From: [WSDOT Aviation Land Use Inquiries and Application Submittals](#)
To: [Chace Pedersen](#)
Subject: RE: [EXTERNAL] CU-23-00006 Honest Cut Meats LLC - Notice of Application
Date: Thursday, December 28, 2023 2:16:13 PM

From: [Connor Armi](#)
To: [Chace Pedersen](#)
Cc: [Guy Moura](#); [Hanson, Sydney \(DAHP\)](#)
Subject: Re: CU-23-00006 Honest Cut Meats LLC - Notice of Application
Date: Tuesday, January 2, 2024 10:29:03 AM

SUBJECT: WDFW COMMENTS ON CU-23-00006 HONEST CUT MEATS

TO: All Staff
FROM: Public Works Plan Review Team
DATE: January 17th, 2024
SUBJECT: CU-23-00006 Honest Cut Meats LLC

DATE: 10/30/2023
JOB: 2619.0001
BY: DDS
SCALE: 1" = 80'
FIGURE NO. 3 of 3

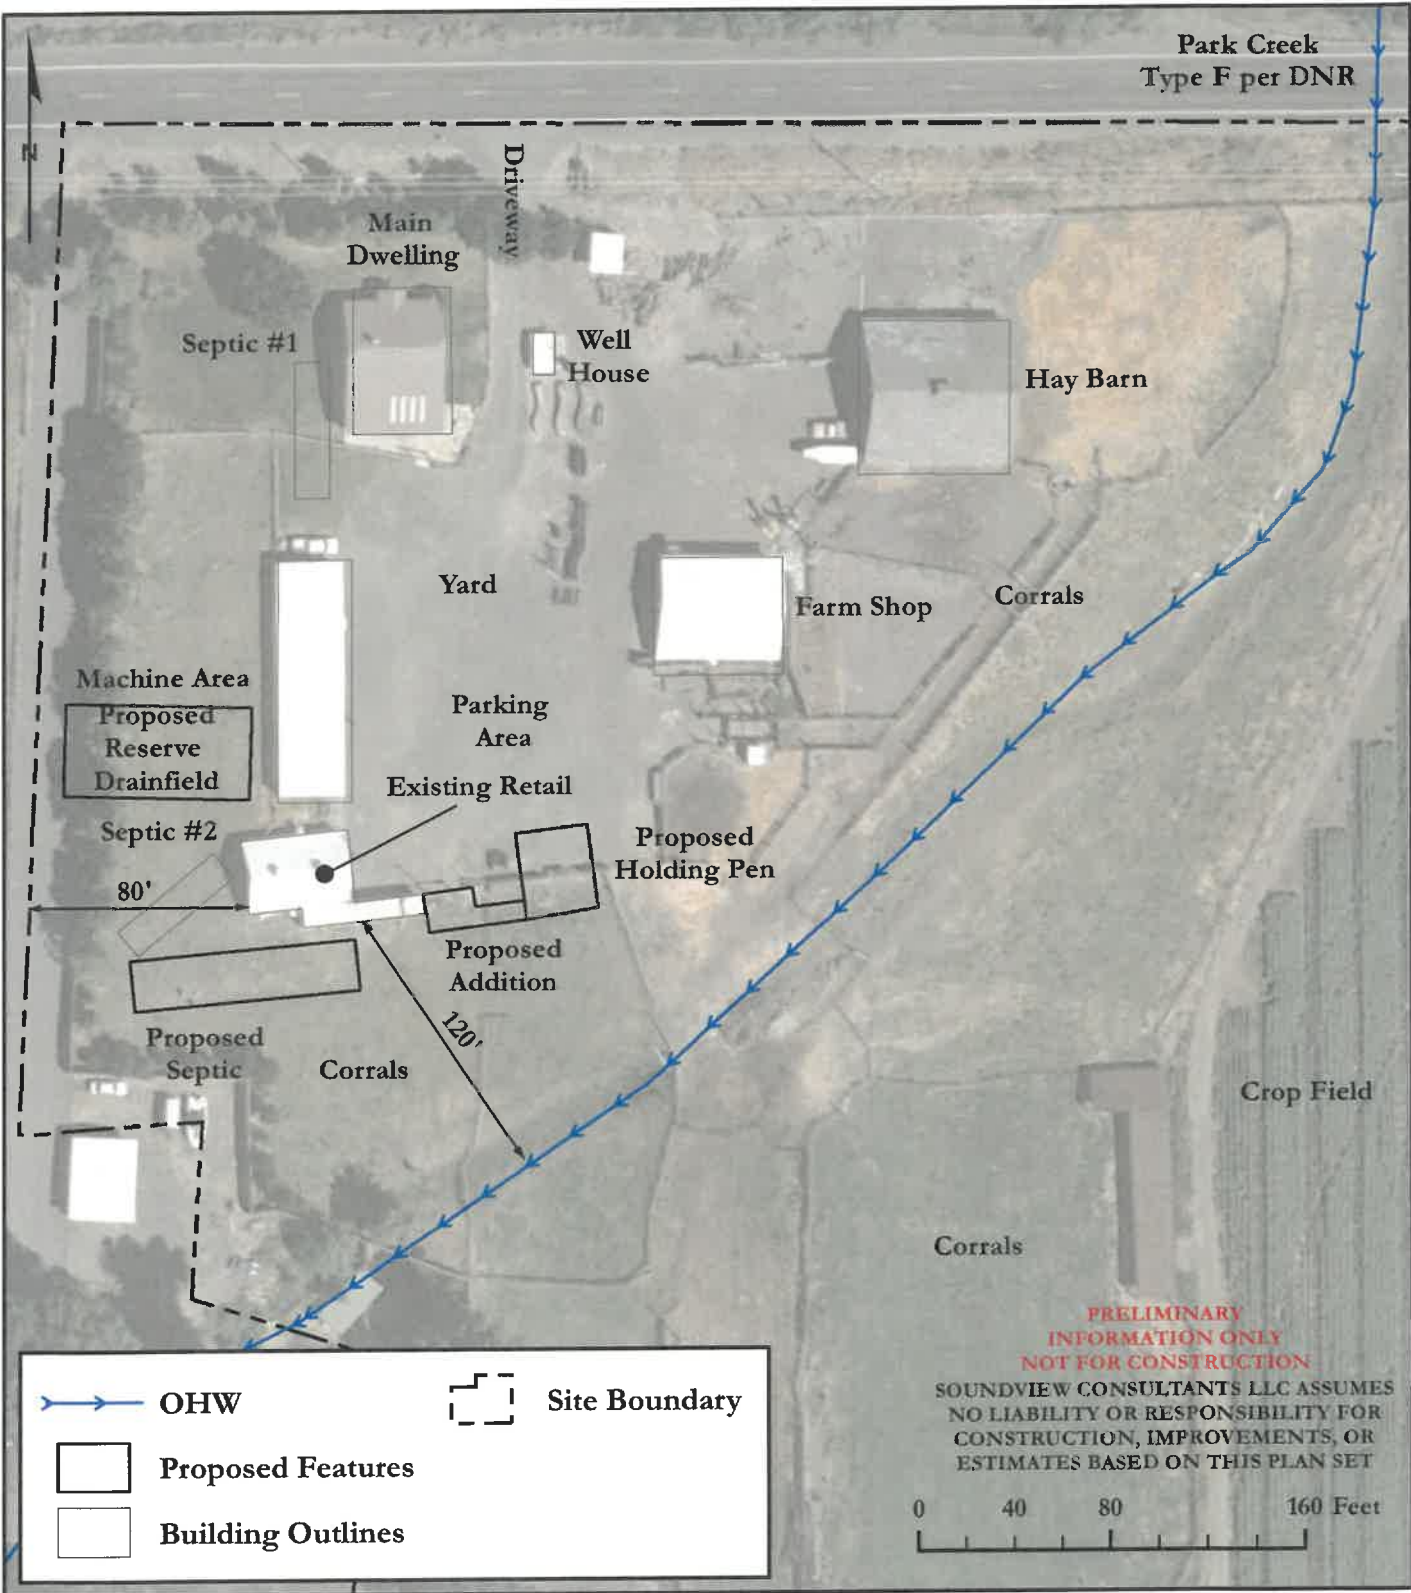
The use of prefabricated structures is likely to minimize the overall footprint and disturbance associated with the project, however there will be at least 480 square feet of new impervious surfaces near Parke Creek and a proposed holding pen that will likely send runoff toward Parke Creek. At least portions, if not all, of the development is within 100 feet from Parke Creek. The standard buffer width in the County's Critical Areas Ordinance would call for a 100-foot buffer plus a 15-foot setback. WDFW's guidance for riparian ecosystems in this location also recommends a 100-foot minimum setback to protect water quality. Ecology's [Voluntary Clean Water Guidance for Agriculture](#) recommends animal confinement areas (holding pens) be placed at least 150 feet away from streams in Eastern Washington and livestock exclusion of at least 100 feet to allow for a fully functioning riparian ecosystem.

The proposed prefabricated structures appear to be located near or within the 100-year floodplain as mapped by FEMA. Unmitigated placement of structures within the floodplain may result in

There may be some gray area as to the applicability of the VSP to this proposal, but WDFW strongly encourages the applicants to include native woody riparian vegetation along Parke Creek to mitigate impacts from placing and operating these new facilities in close proximity to Parke Creek. Enhancing the riparian vegetation through this reach would help ensure the project does not degrade the water quality or Fish and Wildlife Habitat Conservation Areas on the property and would be consistent with [Kittitas County's VSP Approved Work Plan](#). Establishing native woody vegetation along Parke Creek in this location may also help control the invasive reed canary grass that dominates the riparian area on this property.

increased flood risks to existing structures and agricultural infrastructure. If compensatory flood mitigation is needed, WDFW recommends consideration of inset floodplain terraces adjacent to Parke Creek for effective flood mitigation and improved fish and wildlife habitat. We would be pleased to work with the applicants to further explore this option.

WDFW recommends a robust riparian establishment project be incorporated into the project proposal such that the project will be consistent with the goals for the local VSP work group. We welcome the opportunity to collaborate with the applicants and County to ensure this project will protect and enhance critical areas while also maintaining agricultural viability in Kittitas County.
